Your Ref: P/20/18/DOC

Town & Country Planning Act 1990 (as amended)
Town and Country Planning (Development Management Procedure) (England) Order 2015
Approval of details reserved by conditions imposed under P/107/16/PL relating to conditions 3-
surface water drainage, 4-schedule of materials & finishes, 5-landscape scheme, 6-screen
wall/fence details, 8-site set up during construction, 10-storage of waste & recycling details , 11-
placement of 2 No. nesting opportunities for birds & 14-external lighting details.
7 Webb Close Pagham,,

Arun District Council have decided to **REFUSE details reserved by condition for the following reasons:**

PROPOSED
SITE PLAN

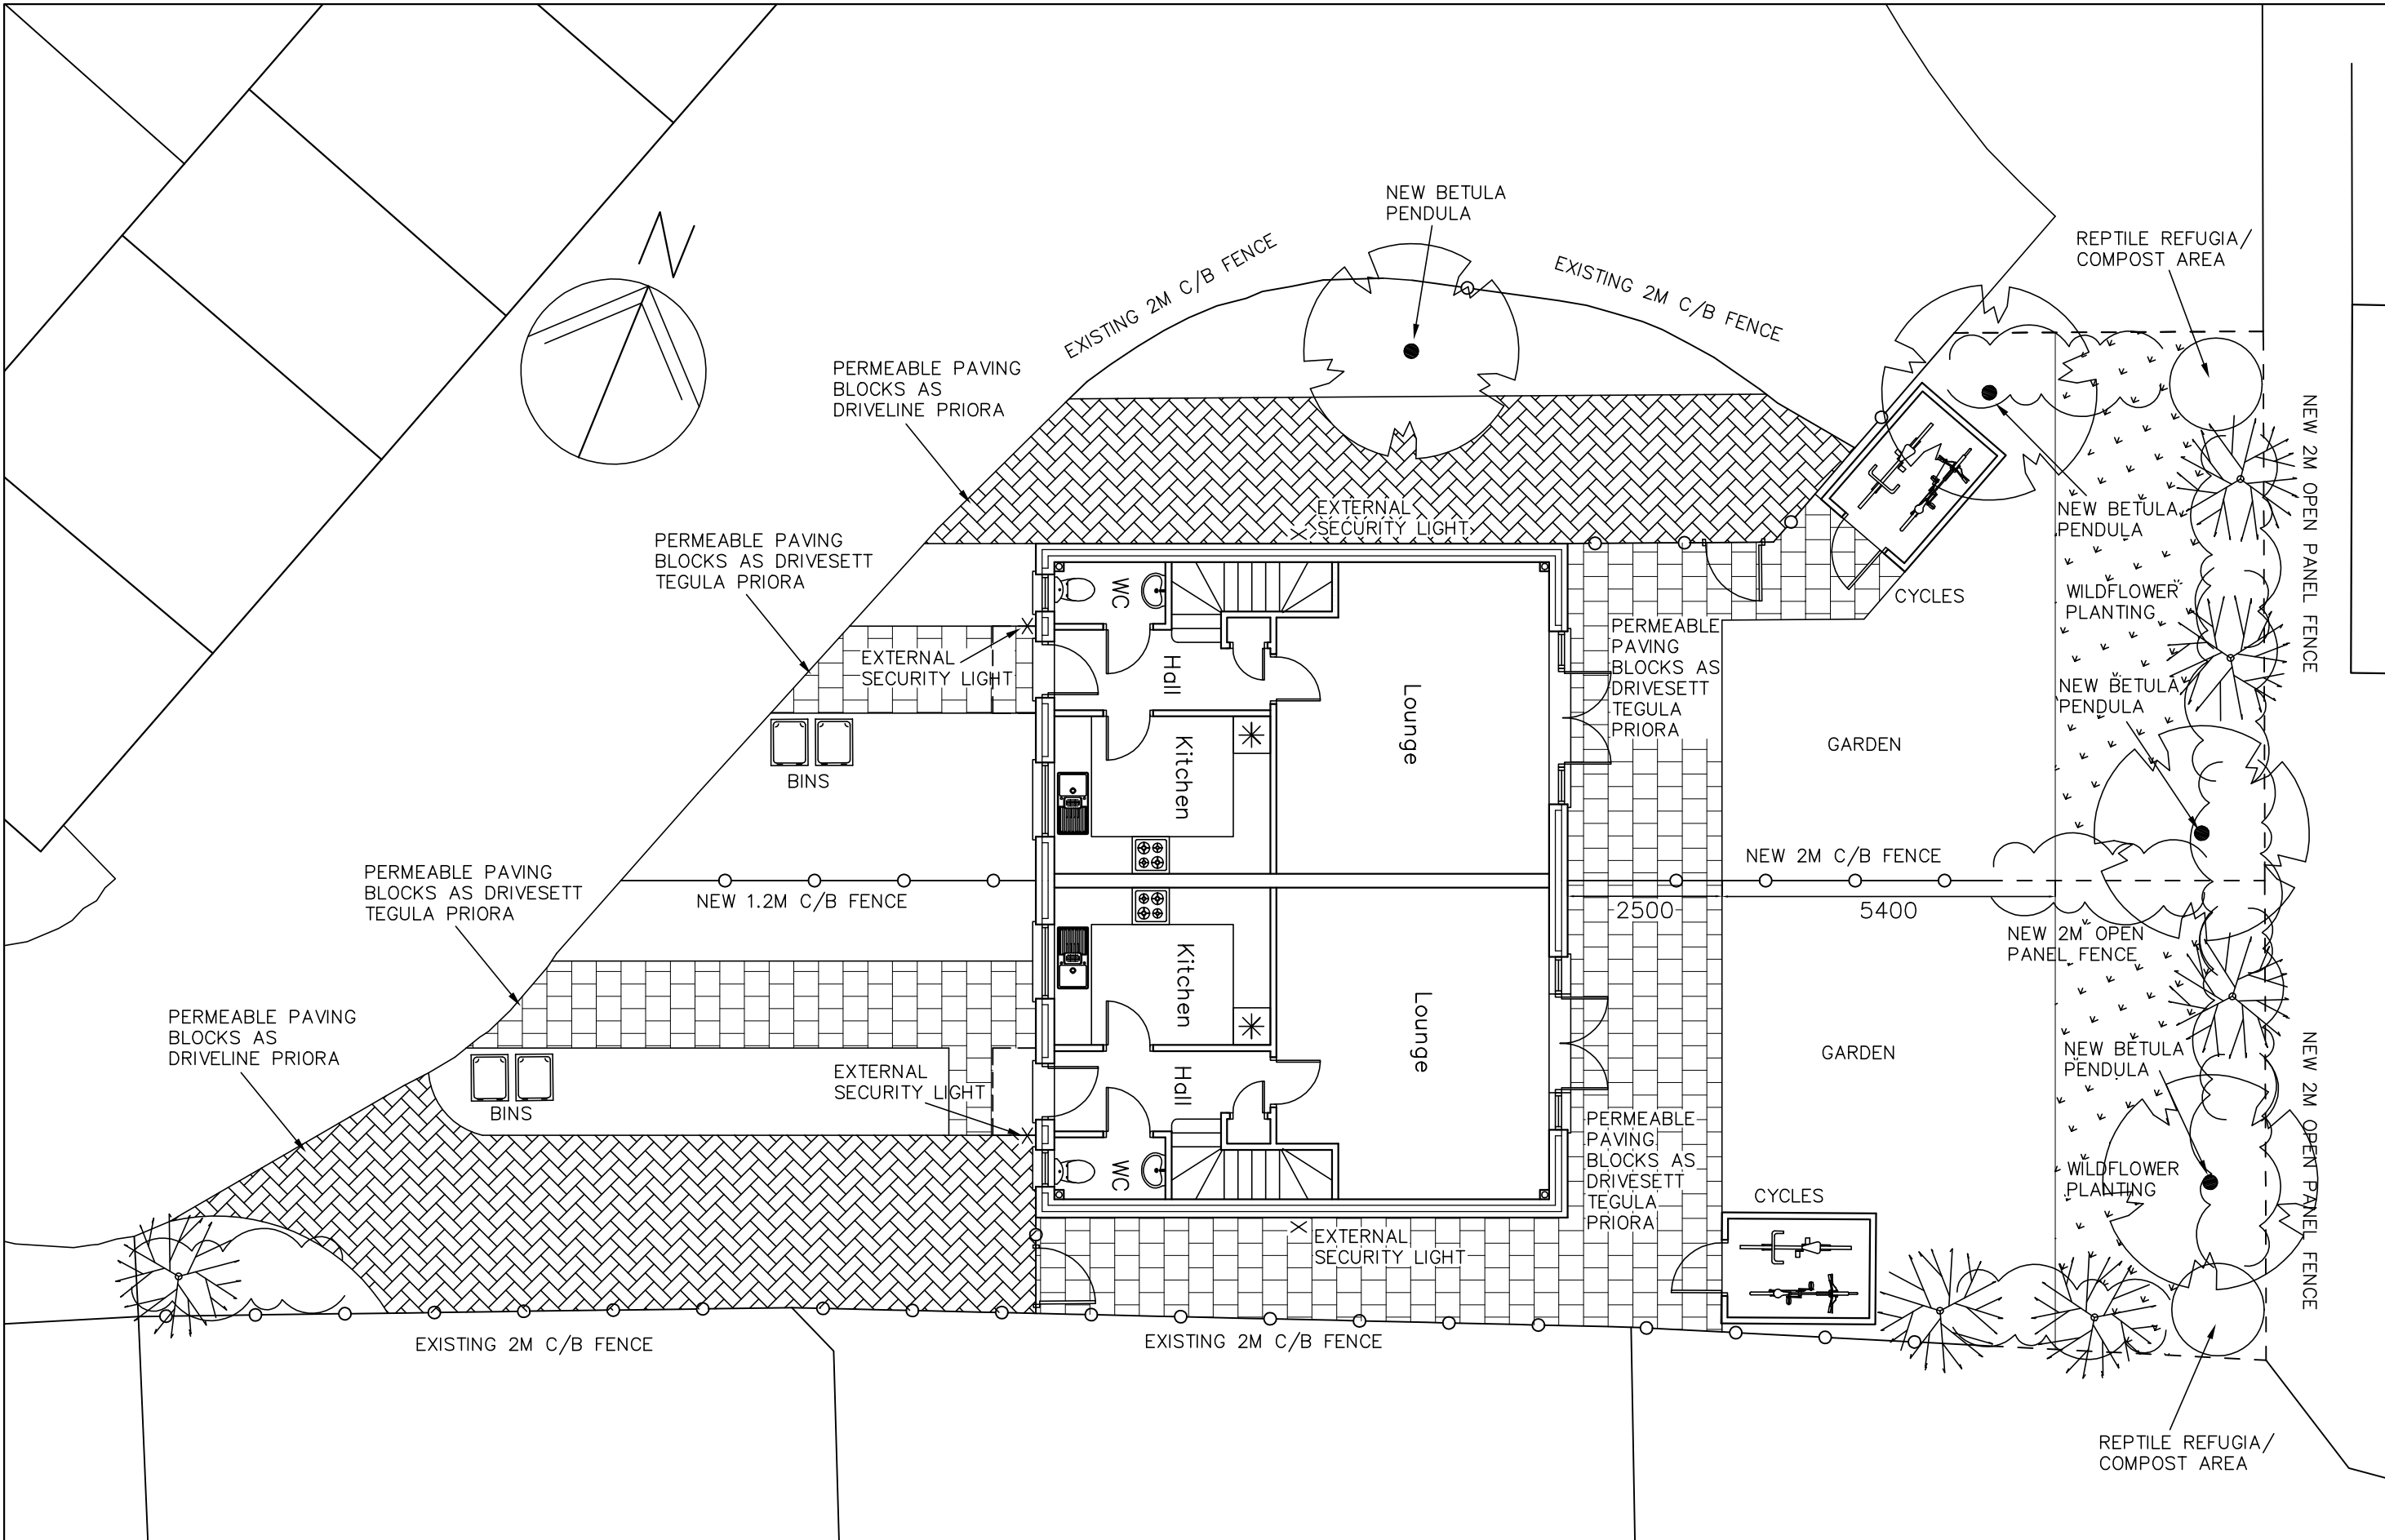
"Drawings submitted under application P/20/18/DOC and additional Planning Statement Feb 2018 proposes a suitable landscape scheme and provide good detail regarding species choice being proposed. However these drawings need to detail actual numbers being proposed for the hedging species rather than just planting densities plus the size at time of planting for the hedging and trees. We would request that this information is submitted for approval therefore we would not recommend the discharge of Condition 5 landscaping on application AP/20/18/DOC imposed under P/107/16/PL until this docdeci

We wrote to you on the 17th April to make you aware of the need for actual numbers proposed for the hedging species and the size at time of planting for the hedging and trees. However, to date, no further details have been provided. As such, the condition cannot be discharged and you will need to make a revised submission.
